Your Ref: OWPC2527
Our Ref: A/46/14/HH 31-03-2014
Please ask for:
Mr P Cleveland

Retention of infill Brickwork to front boundary wall. This application affects the character and appearance of Angmering Conservation Area

Woodford Villas 2 High Street Angmering

DRAWING TITLE
NEW FRONT BOUNDARY WALL
ELEVATIONS, PLAN AND SECTION

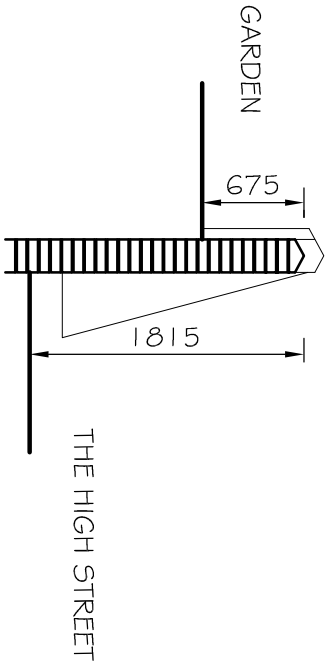
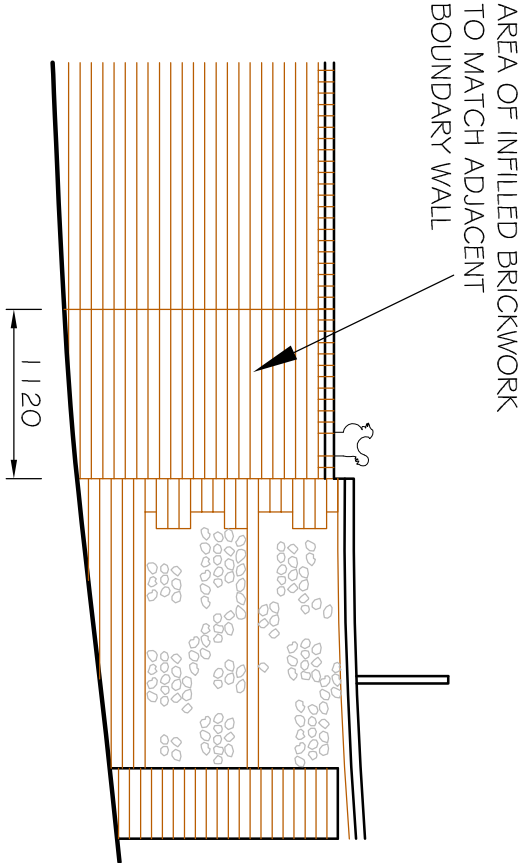
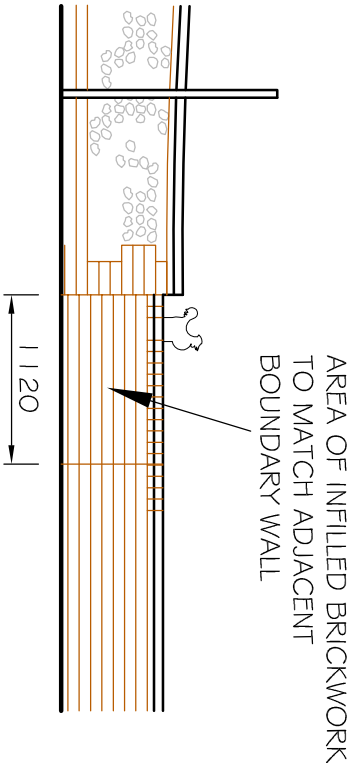
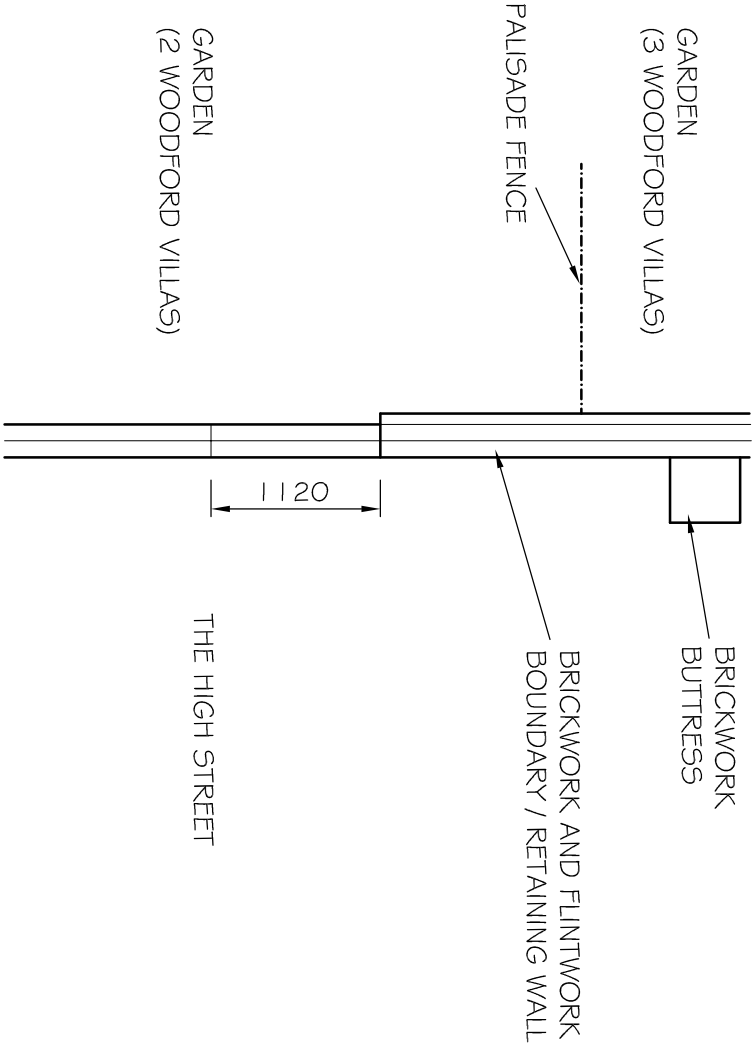
- 1. The blocked access to the wall has been confirmed as a legal access to my property and the other properties at Angmering Villas and Woodford Villas by my solicitors(Bennett- Griffin).*
- 2. The materials used are out of keeping with the flint wall in a conservation area and inappropriately "topped off" with a " Terracotta Chicken"!*
- 3. The height of the construction does not conform with legal requirements.*
- 4. There are on- going legal investigations into the historic access.*
